BRIEF DESCRIPTION OF REQUEST
Afra Construction, on behalf of West Mesa RV Park formerly known as Paradise RV Park, request Final Sign Off for Site Development Plan approved by EPC

REFERENCE: WEST MESA PARK – FORMERLY KNOW AS PARADISE RV PARK
PROJECT NO: 1008330 / EPC-40073 PHASE II. AND PROJECT NUMBER PR-2024-010907- DFT APPLICATION NUMBER SI-2024-01331.

Based on the NOTICE OF DECISION and recent comments from the DFT staff, we have addressed all the Conditions of Approval in **bold text** as follows:

C-03

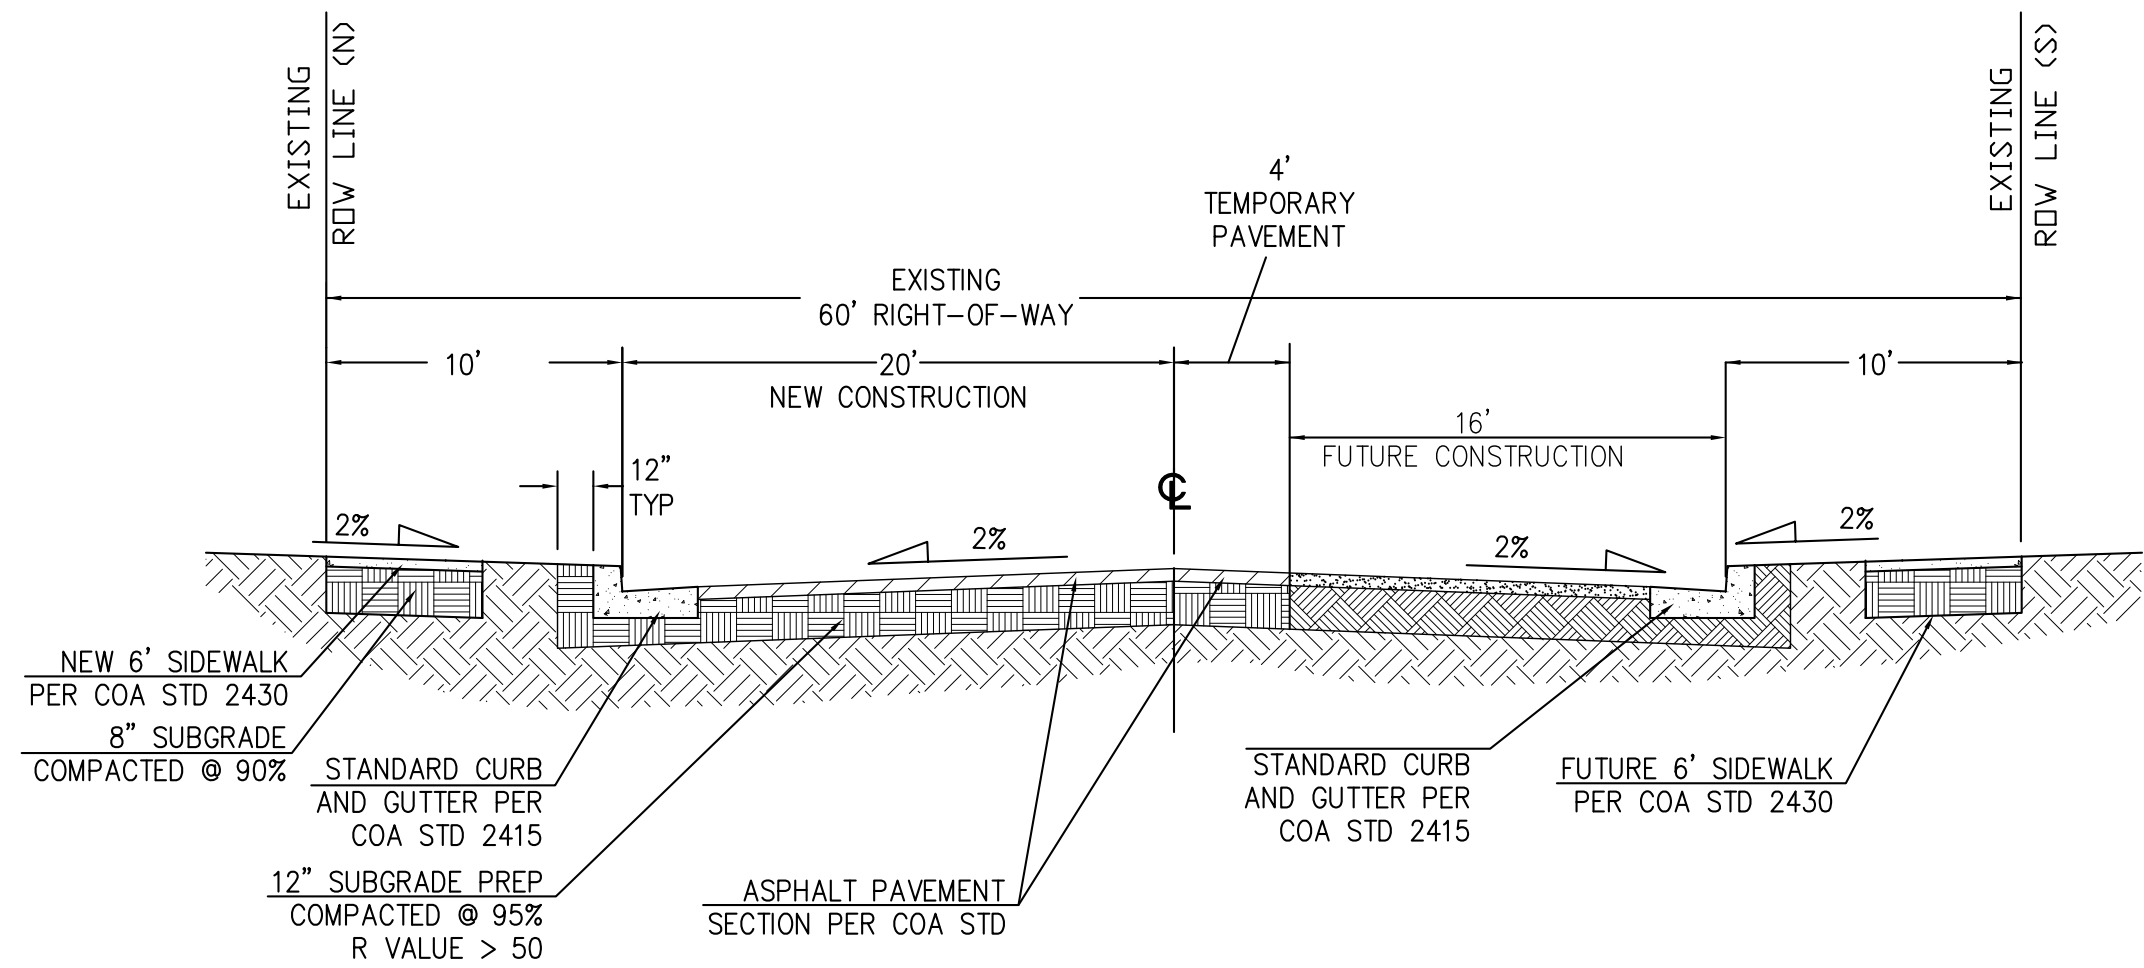
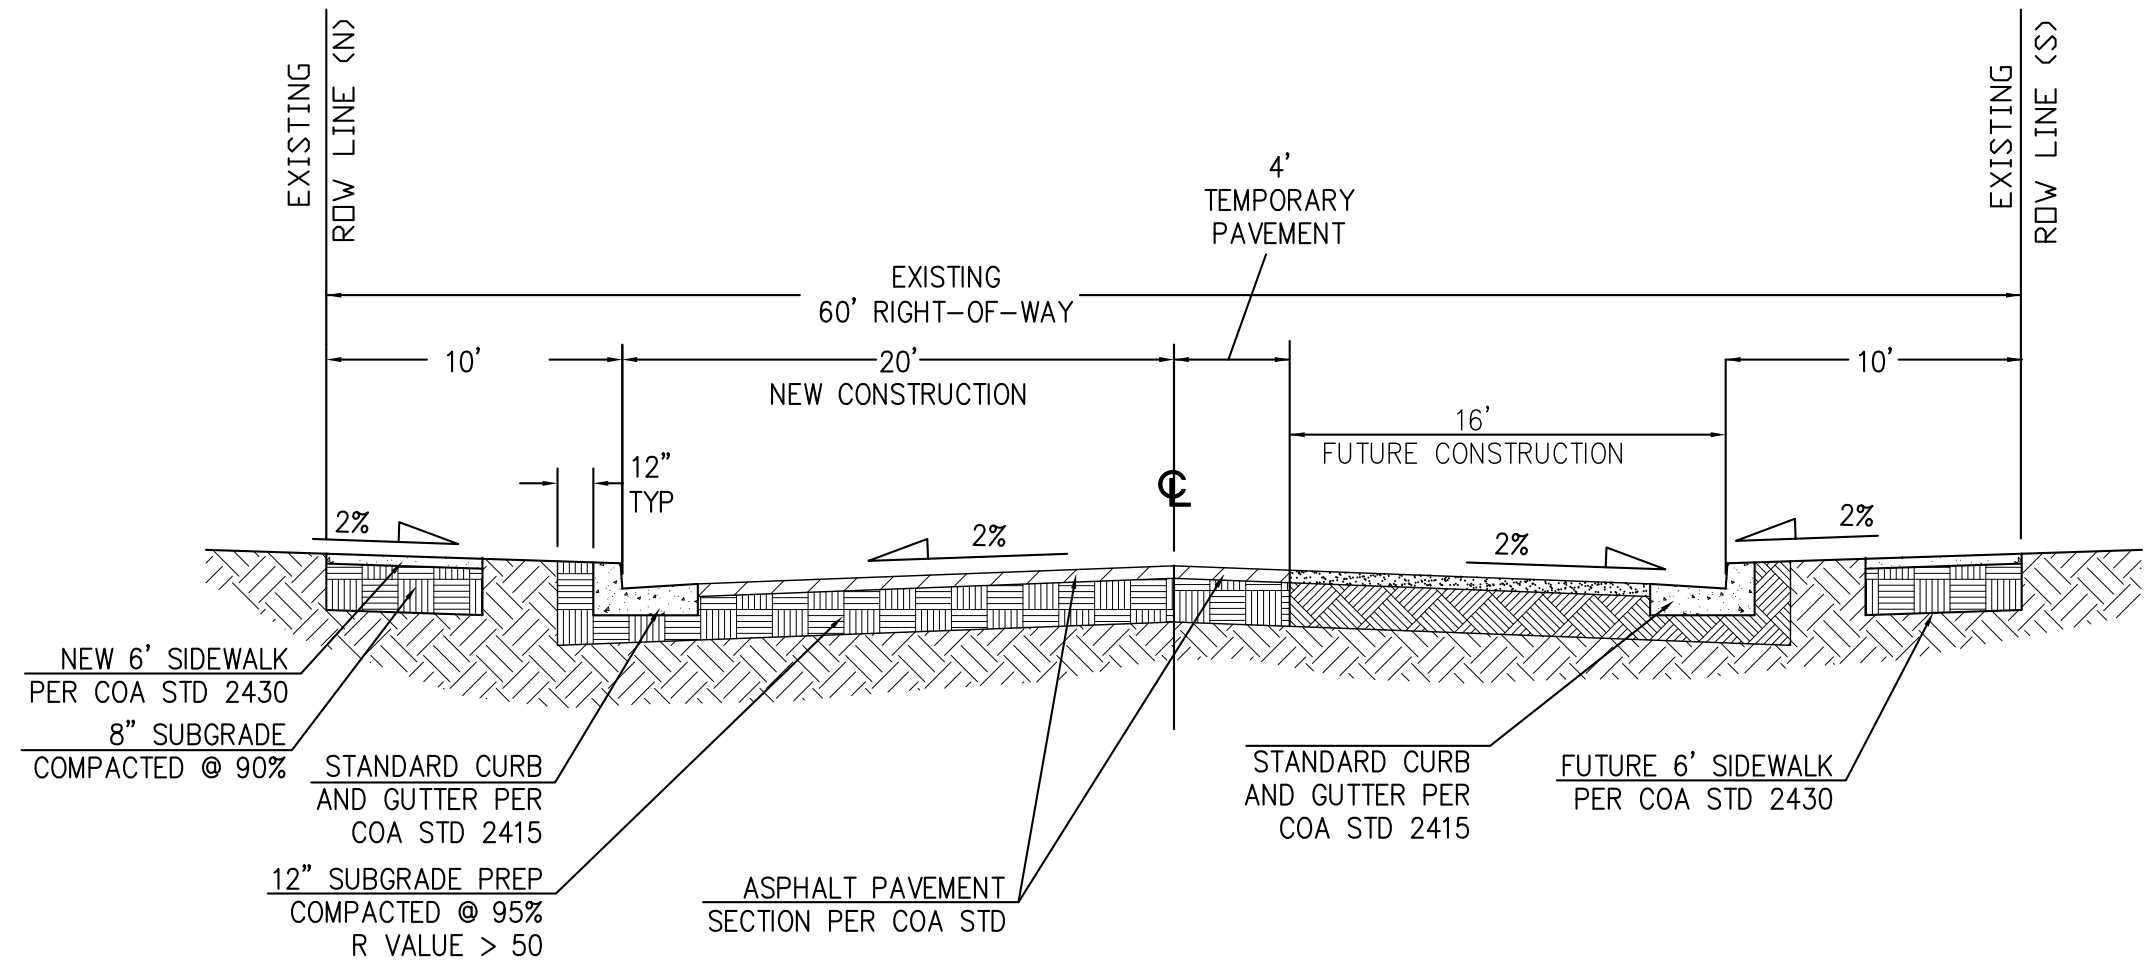
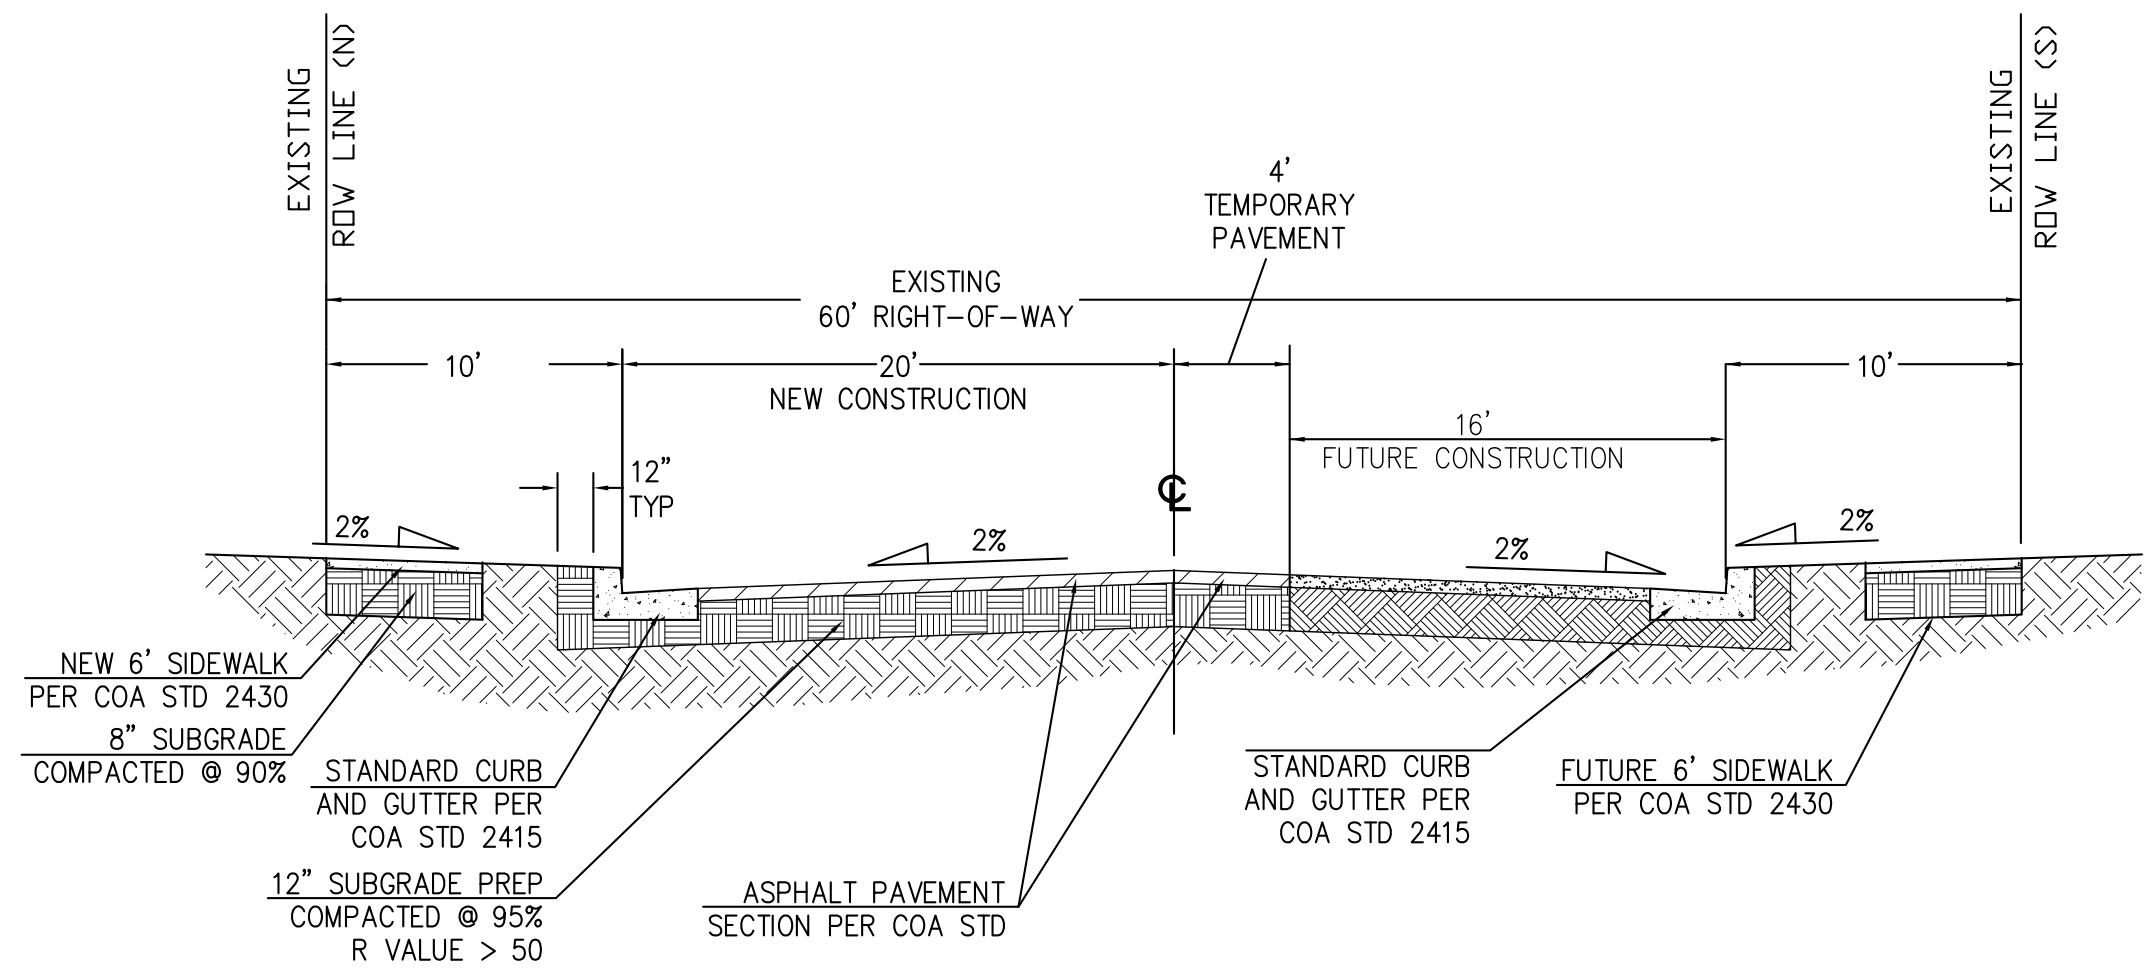
- f. Please clarify the limits of all paving.

All Limit of Pavements for Volcano, Avalon and 102nd Street are shown on the Typical Cross Section Sheet C-03

L1

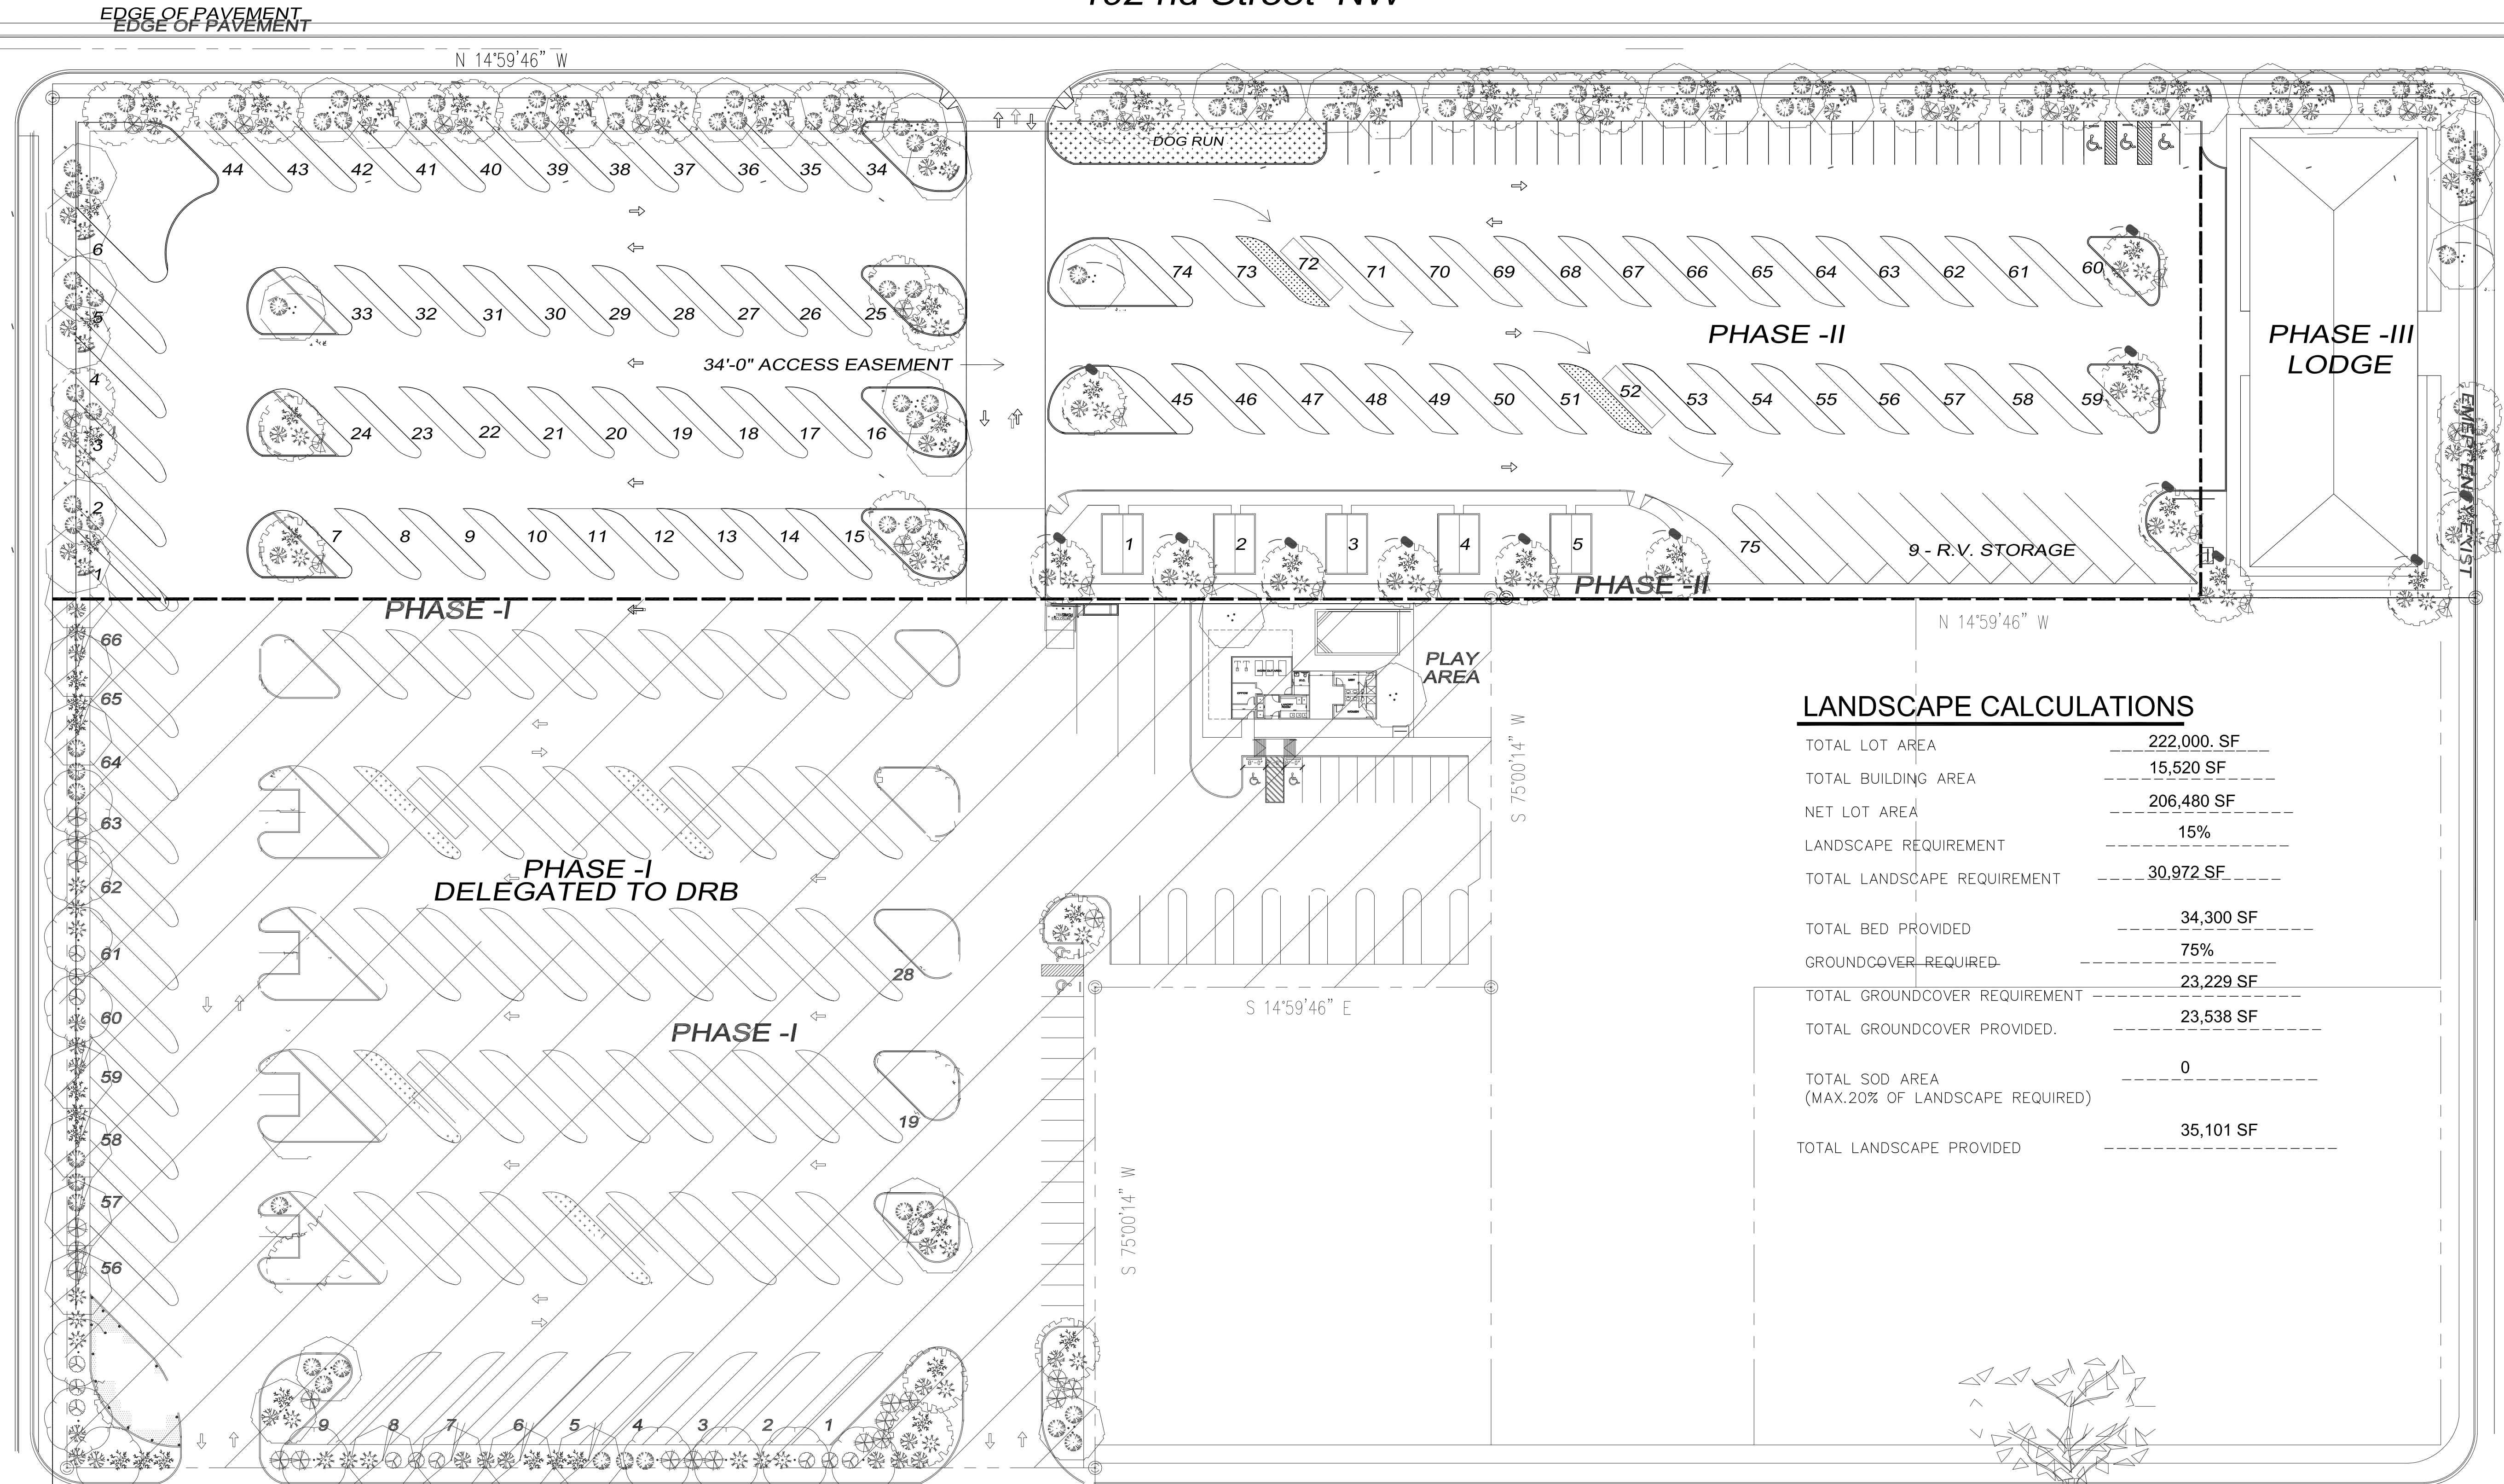
5. Dimensions of the landscape beds and the quantity of each type of planting shall be provided on the Landscape Plan.

A Landscape Calculation Table is added on Sheet L1. Also, please note that the DFT staff has requested that all the plan sheets be signed and stamped including the Landscape Plans. Since the original Landscape Plans was developed by Hilltop Landscaping which is no longer in service, the applicant had to hire the services of Mitchell Associates, Inc to revise the Landscape Plans and also provide stamped drawings. The three sheets LS-101, LS-102 and LS-103 are hereby separately attached with the Submittal Package. It is now up to the discretion of the Planners to replace the original Landscape Plans with the Three attached “stamped” sheets.
